Please ask for: Ms Iqraa Malik
Email: iqraa.malik@terraquest.co.uk
Telephone: 01212341390
Our Ref: FG/85/20/HH
Your Ref:
Date: 28th July 2020

Application for Planning Permission for Works or Extension to a Dwelling

Development: Garden outbuilding.
Location: 18a Ocean Drive Ferring BN12 5GJ

BLOCK PLAN 1:500 @ A4
PROPOSED OUTBUILDING

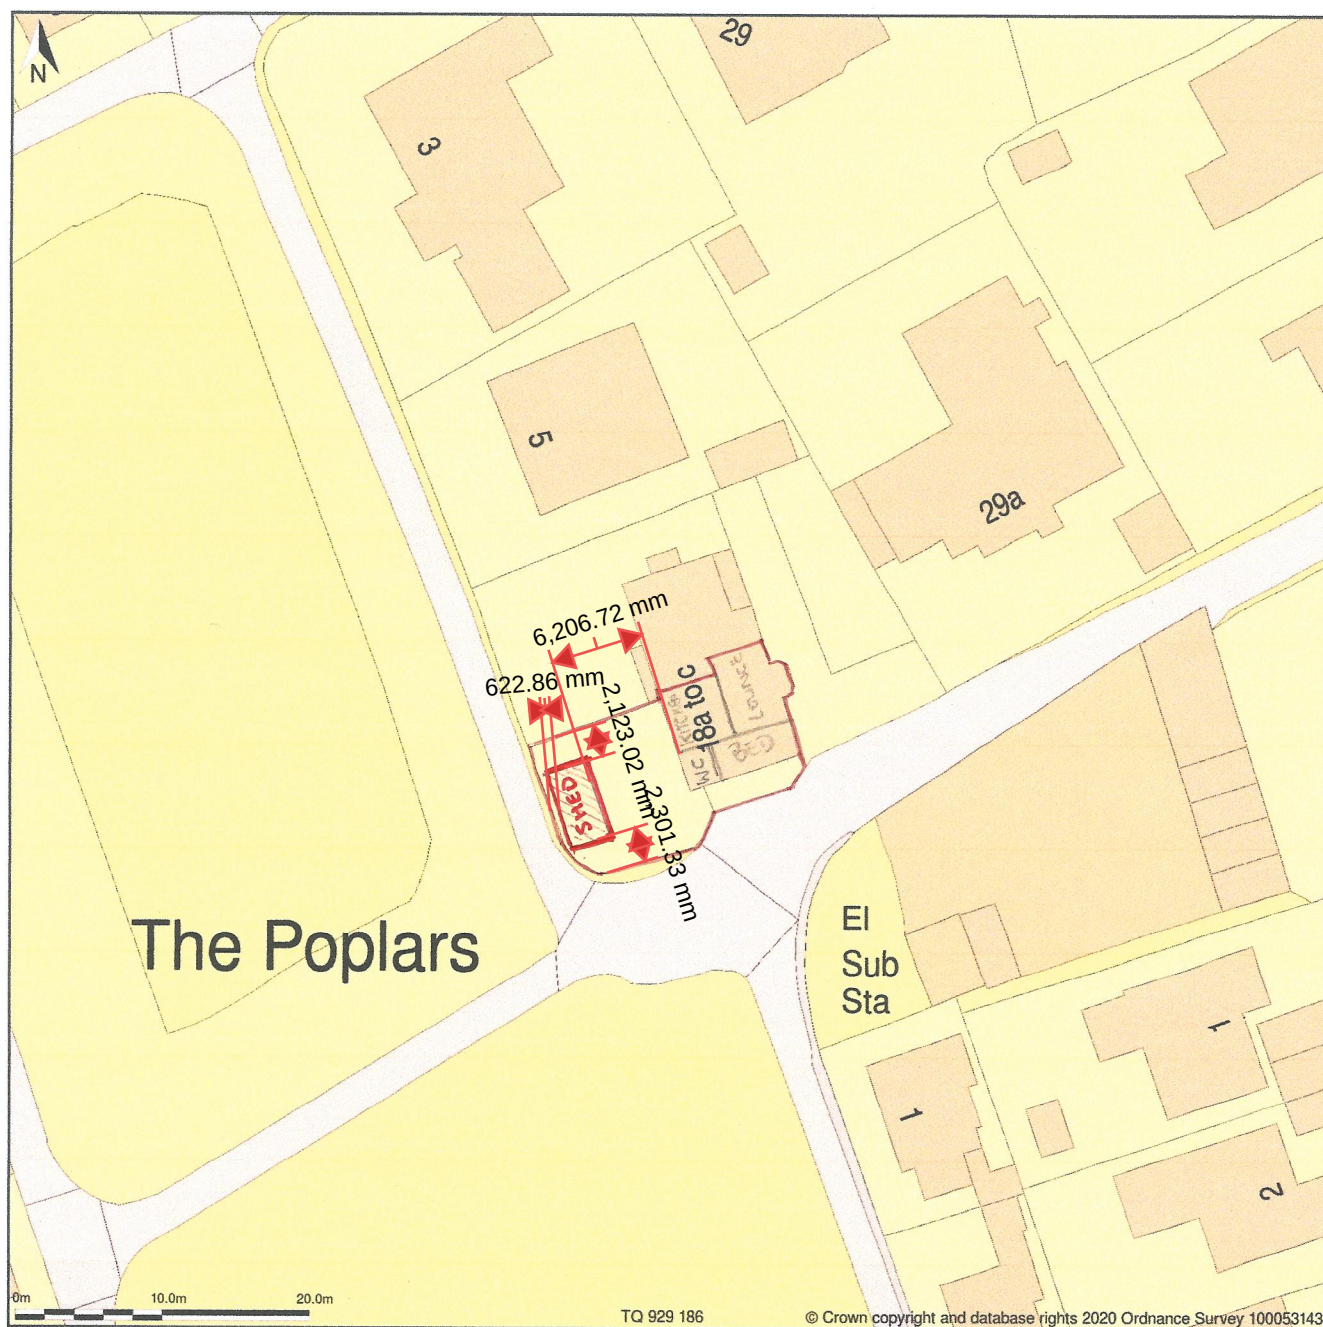
The proposed outbuilding measures inconsistently between the block plan and the floor plan. Please amend.

All scale bars on the plans submitted do not measure to scale. Please amend.

Block Plan + Floor Plans *Block plan purchased 1:500 @ A4.*

*Block plan 1:500 @ A4
Floor plan 1:100 @ A4 } see updated note for
shed dimensions*
